**KIRKLEES METROPOLITAN COUNCIL
INVESTMENT & REGENERATION SERVICE**

**DELEGATED DECISION TO DETERMINE APPLICATIONS FOR
NON-MATERIAL AMENDMENTS**

Reference No: **2025/NM/92636/E**

Site Address: 20, North Street, Heckmondwike, WF16 0AY

REAR

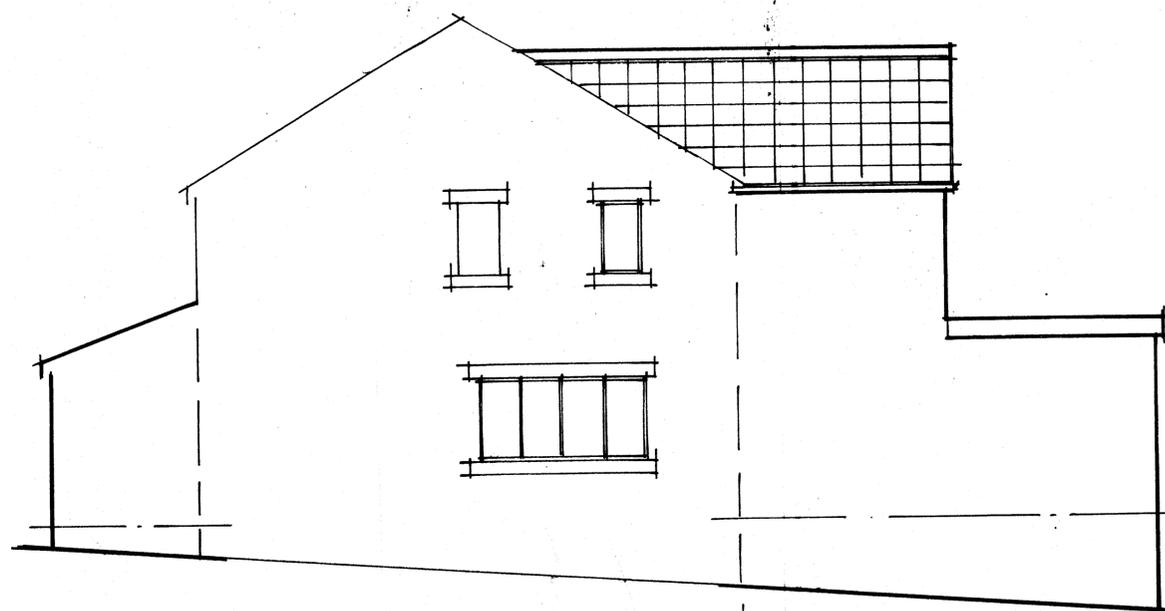
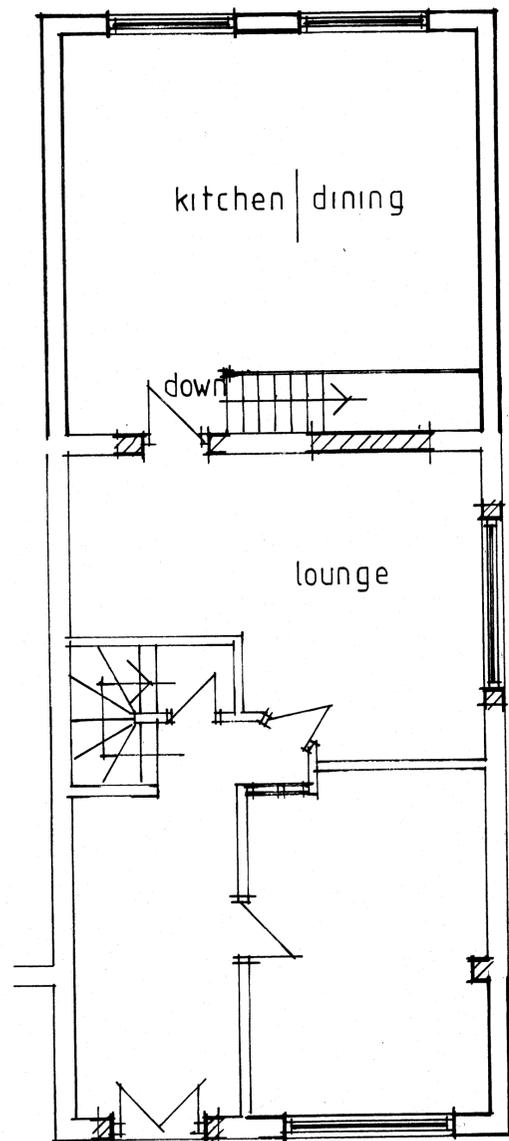
Although the proposed alteration would not fall outside the description of the original approval, the formation of a lower ground floor would elongate and alter the appearance. The alteration would be visually different from the approved plans. The altered scheme would therefore need to be assessed as a new planning application.

The design would appear awkward relative to the dwelling with the additional vertical emphasis, in addition the proposal would introduce a greater level of massing and an increase in the height of elements of the approved scheme.

It is noted that the originally approved scheme features a single storey flat roof element which could have been undertaken as pd due to completion of a prior approval application. The proposed amendment would see an enlargement of this element, which would go beyond the scope of permitted development and there would not be a realistic 'fall back' present for this element of the scheme. As such it is considered that assessment against the Council's SPD in terms of whether there is any justification for non compliance of this element of the scheme would need to be undertaken and may not be successful in this case given the proposal would now see a two storey flat roof designed extension.

In addition the additional impact in terms of extra massing and whether this would unacceptably overshadow or lead to an unduly overbearing development would need to be considered. The proposal has the potential to significantly impact neighbouring occupiers in this case.

BASEMENT

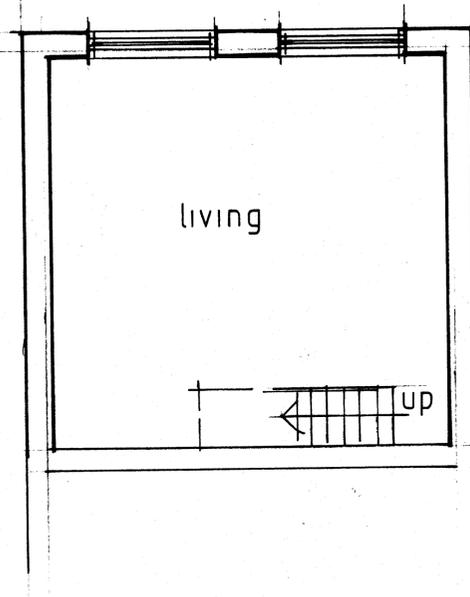
It is noted that the proposal would be to create a basement level of accommodation, it is not clear the extent of additional engineering operations required to enable such works however in light of the consideration the scheme would not constitute a non-material amendment in any event it has not been requested to set out further explanation in this regard.
